**re: Grading and Servicing Plan Review**  
**Proposed Warehouse Development**  
**1540 Star Top Road, Ottawa, Ontario**  
**to: BBS Construction (Ontario) Ltd. – Mr. Pete Van Grootheest –**  
[pete@bbsconstruction.ca](mailto:pete@bbsconstruction.ca)  
**date: October 11, 2023**  
**file: PG6674-MEMO.01**

Paterson reviewed the following grading plan prepared by McIntosh Perry for the subject site:

- Grading Plan – 1560 Star Top Road, Boone Plumbing Warehouse – Project No. CCO-23-3725 – Drawing No. GP, Revision 2 dated October 6, 2023.

SANITARY STRUCTURE TABLE

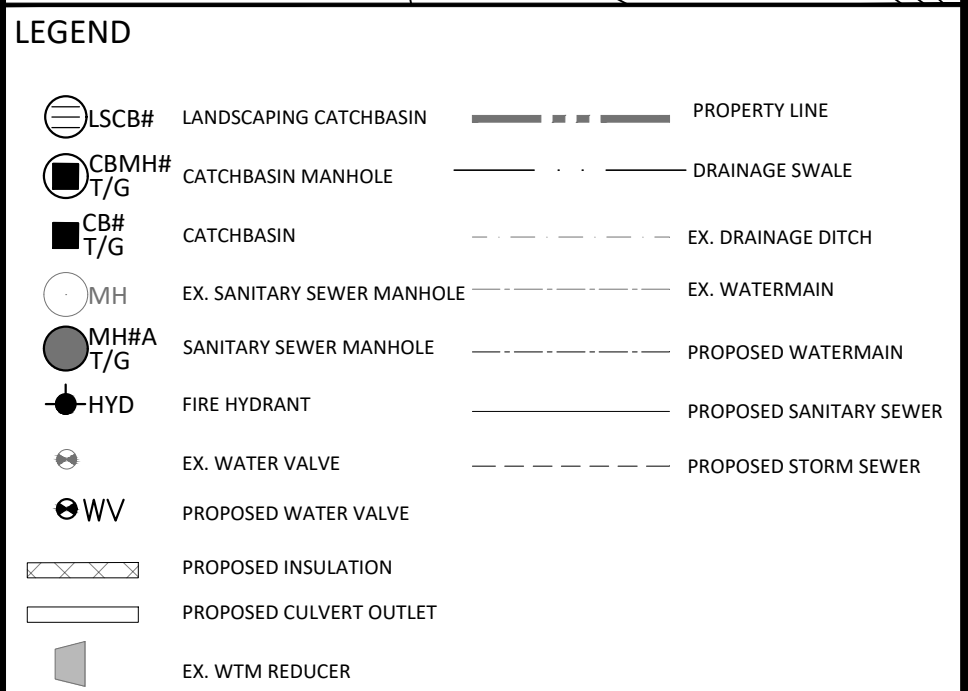
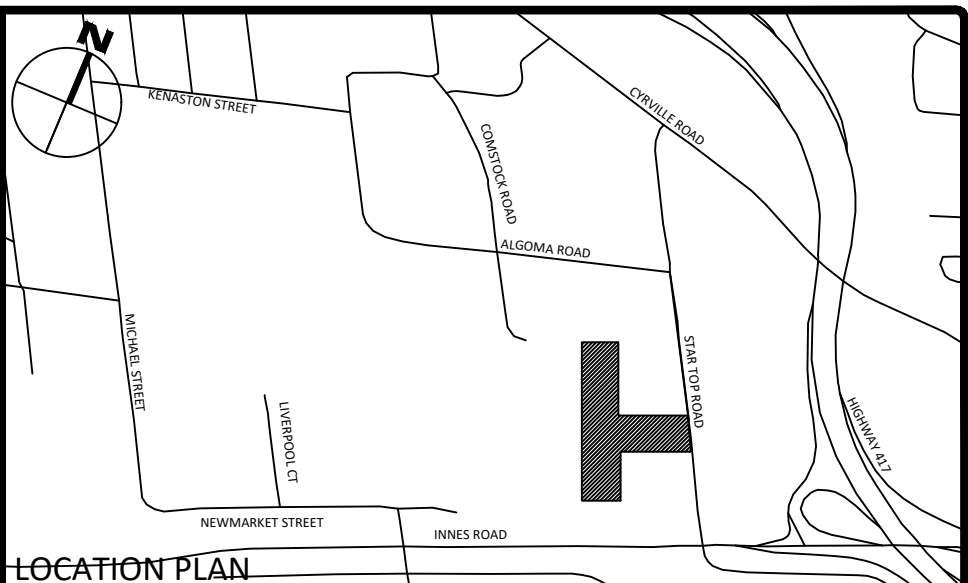
Based on our review, the majority of the invert elevations for service pipes entering the stormwater and sanitary manhole structures throughout the subject site were observed to be found in the frost zone (i.e., approximately 1.8 m below the finished ground surface). Soil cover over the landscape storm sewer and some segments of the storm service pipe within the parking areas and access lanes have insufficient frost protection. However, it is expected that significant frost heave issues will not occur for the storm service alignments within the landscaping area. Please see the service pipe alignments where insufficient frost protection has been provided and rigid insulation is recommended:

- CB 1 South-running storm pipe; approximately 1.1 m of soil cover to invert.
- CB 2 North-running storm pipe; approximately 1.1 m of soil cover to invert.
- CB 4 North-running storm pipe; approximately 0.8 m of soil cover to invert.
- STMH 3 & OGS1 East-running storm pipe; approximately 1.22 m of soil cover to invert.

From a geotechnical perspective, those catch basins and the associated leads do require additional insulation within the boundaries of the subject site. the following frost protection criteria should be followed:

Thermal Condition	Soil Cover Provided (mm)	Insulation Dimensions	
		Thickness (mm)	Extension (mm)
Unheated	600 to 900	125	Extend 1200 mm horizontally beyond edge face of the sewer
	900 to 1200	100	Extend 1200 mm horizontally beyond edge face of the sewer
	1200 to 1500	75	Extend 900 mm horizontally beyond edge face of the sewer
	1500 to 1800	50	Extend 600 mm horizontally beyond edge face of the sewer
	1800 to <2100	25	Extend 300 mm horizontally beyond edge face of the sewer

All rigid insulation should consist of either Dow Chemical High-Load 40 (HI-40), Styro Rail SR.P400, or equivalent approved by Paterson. The placement of all insulation within the service trenches must be reviewed and approved by Paterson personnel at the time of construction.
